Consultation Response from KC, Lead Local Flood Authority		
2020/90549 Land west of, Ashbrow Infant and Nursery School, Ashbrow Road, Ashbrow, Huddersfield		
Discharge conditions 4-6,9-15,19,20,22 on previous permission 2019/92940 for erection of 161 residential units including a 50 unit extra care facility (all class C3) and public open space		
Date Responded: 22nd March 2020	Responding Officer: Paul Farndale	Responding Ref:

Condition 10 – Off site surface water drainage.

Drawing Title:
HEADWALL DETAIL
OUTFALL INTO BLACKHOUSE DYKE

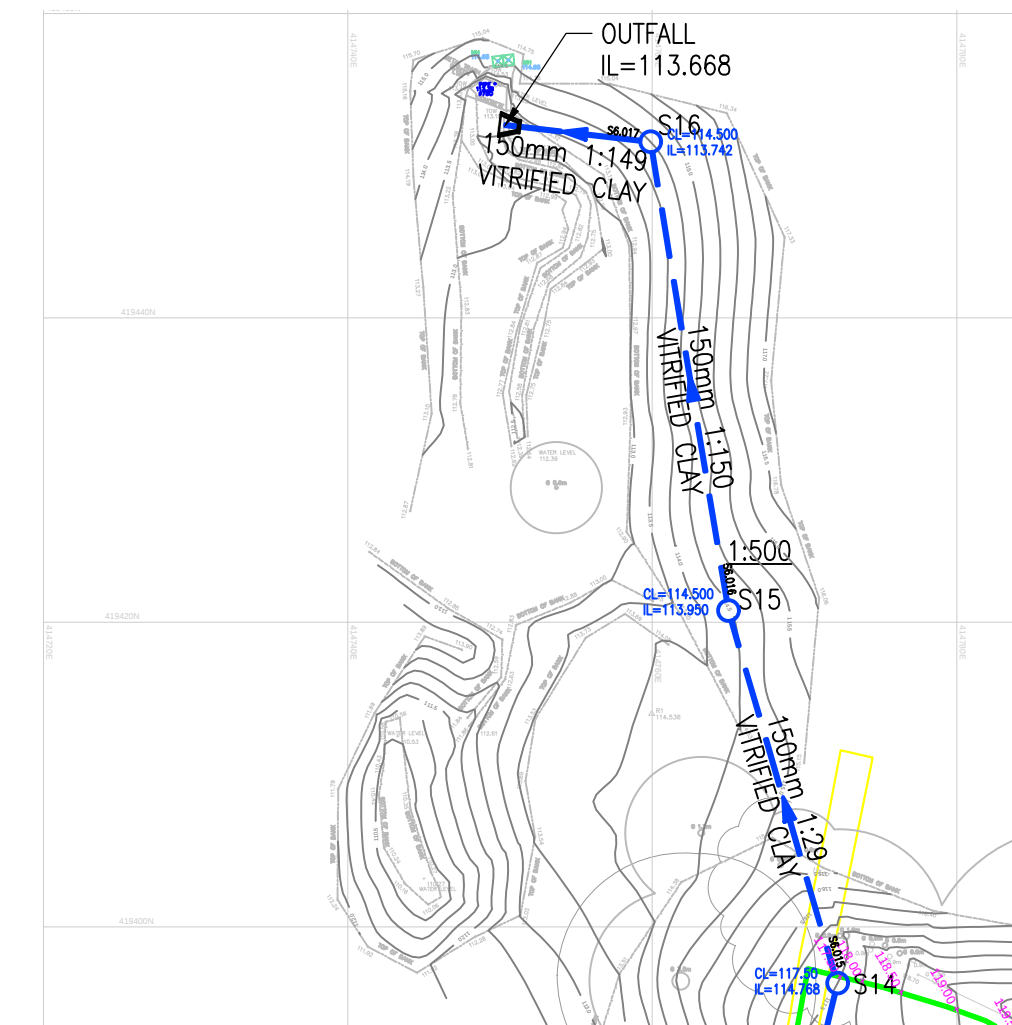
Headwall details 114509/2047A has been supplied. The LLFA has no objection to this or the connection point shown. However, the point of connection and approach is shown different to that on Section 104 drawing 114509/2003Y. The latter drawing should be updated and notation suggesting the outfall is still to be investigated and levels to be verified should be changed to reflect the former drawing. If any investigation and potential change is still envisaged, then we would expect to receive a finalised drawing when appropriate.
